**ACORNS
PROJECTS
LIMITED**

**Cliffe Lane, Gomersal, West Yorkshire
Proposed Section 278 and 38 Highway Works
Stage 1 Road Safety Audit**

**For Sanderson Associates Consulting Engineering
Prepared by Acorns Projects Limited
Safety Traffic Project Management & Highway Engineering Consultants**

JULY 2024

Copy Of Phoenix 2 Duo Recycler (P2-15W with Elite 6x4 chassis)
 Overall Length 11.850m
 Overall Width 3.750m
 Overall Body Height 2.530m
 Min Body Ground Clearance 0.309m
 Track Width 2.530m
 Lock to lock time 4.00s
 Wall to Wall Turning Radius 11.035m

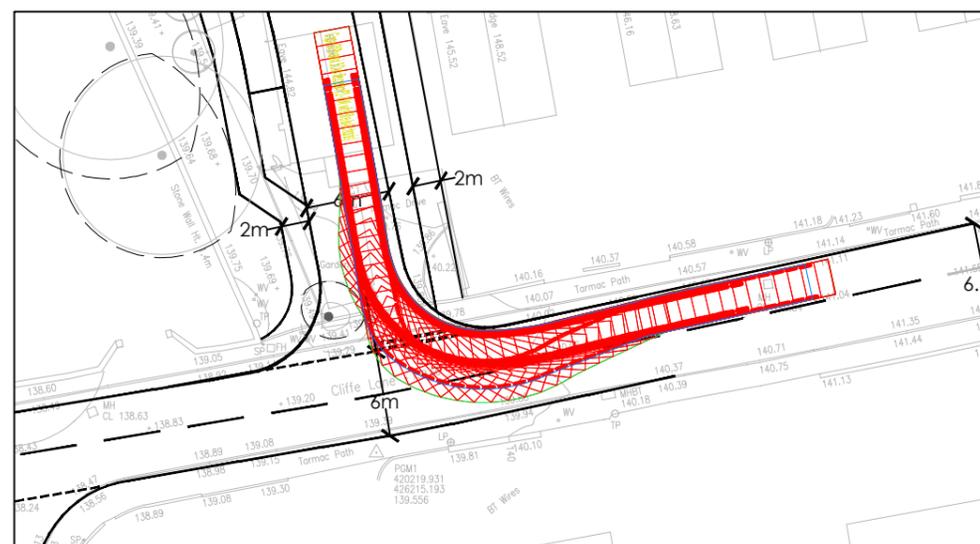
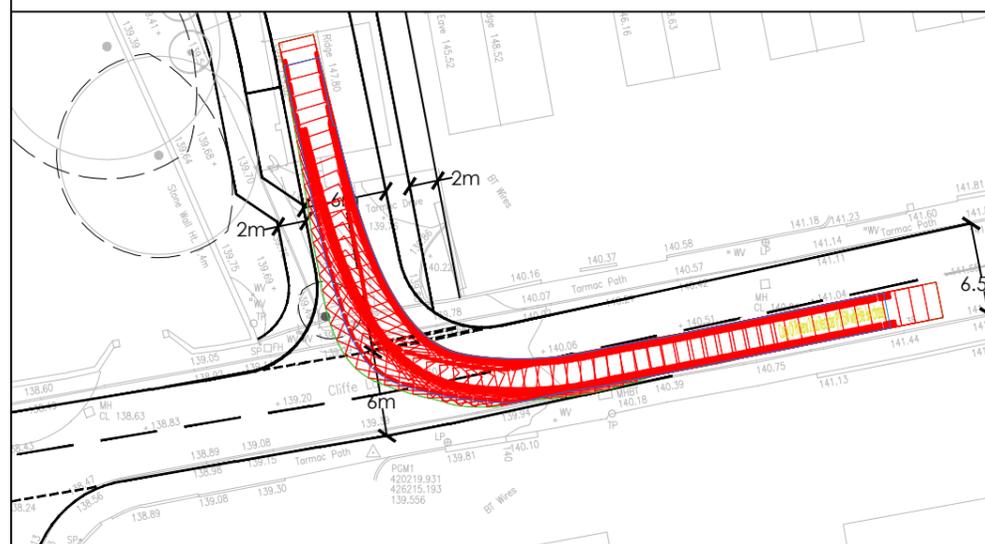
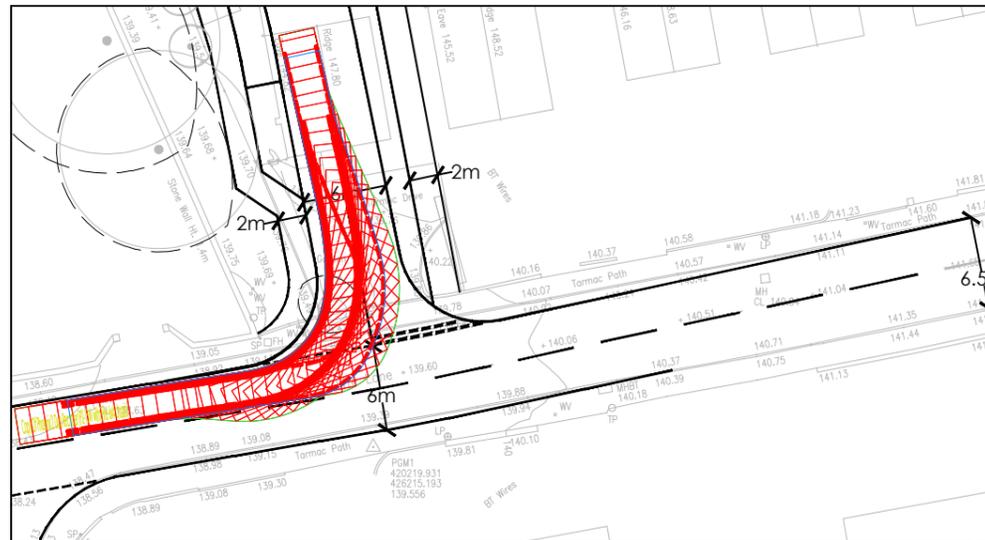
Location 1 - The new priority T-junction in Cliffe Lane (Drawing Nos. 1694-101 Rev J & 152130-001 Rev A).

Summary - The swept path requirements of refuse vehicles turning, entering and exiting the new priority T-junction requires the vehicles' bodies to encroach into the opposing vehicular traffic lanes. This situation could result in a potential increased risk of offside to offside vehicular collisions occurring and head-on type vehicular collisions occurring, whereby vehicle occupants could sustain personal injury.

Detail - The scheme drawings include swept path analysis exercises for a refuse vehicle turning, entering and exiting the new priority T-junction in Cliffe Lane. It is evident from the swept path analysis exercises that in everyday operational terms, encroachment of the opposing vehicular traffic lanes will take place.

Concern arises that the swept path requirements of refuse vehicles turning, entering and exiting the new priority T-junction could lead to a potential increased risk of offside to offside vehicular collisions occurring and head-on type vehicular collisions occurring, whereby vehicle occupants could sustain personal injury.

It is Recommended that junction geometry improvements should be undertaken, such that the potential collision scenarios are reduced or mitigated.

If for whatever reasons the above recommendation cannot be adopted, then it is Recommended that approval for the current layout proposals should be sought and agreed with the Overseeing Organisation, i.e. the Local Highway Authority, Kirklees Council, via the DMRB GG 119 Road Safety Audit Response Report and Table F.4 Decision Log.
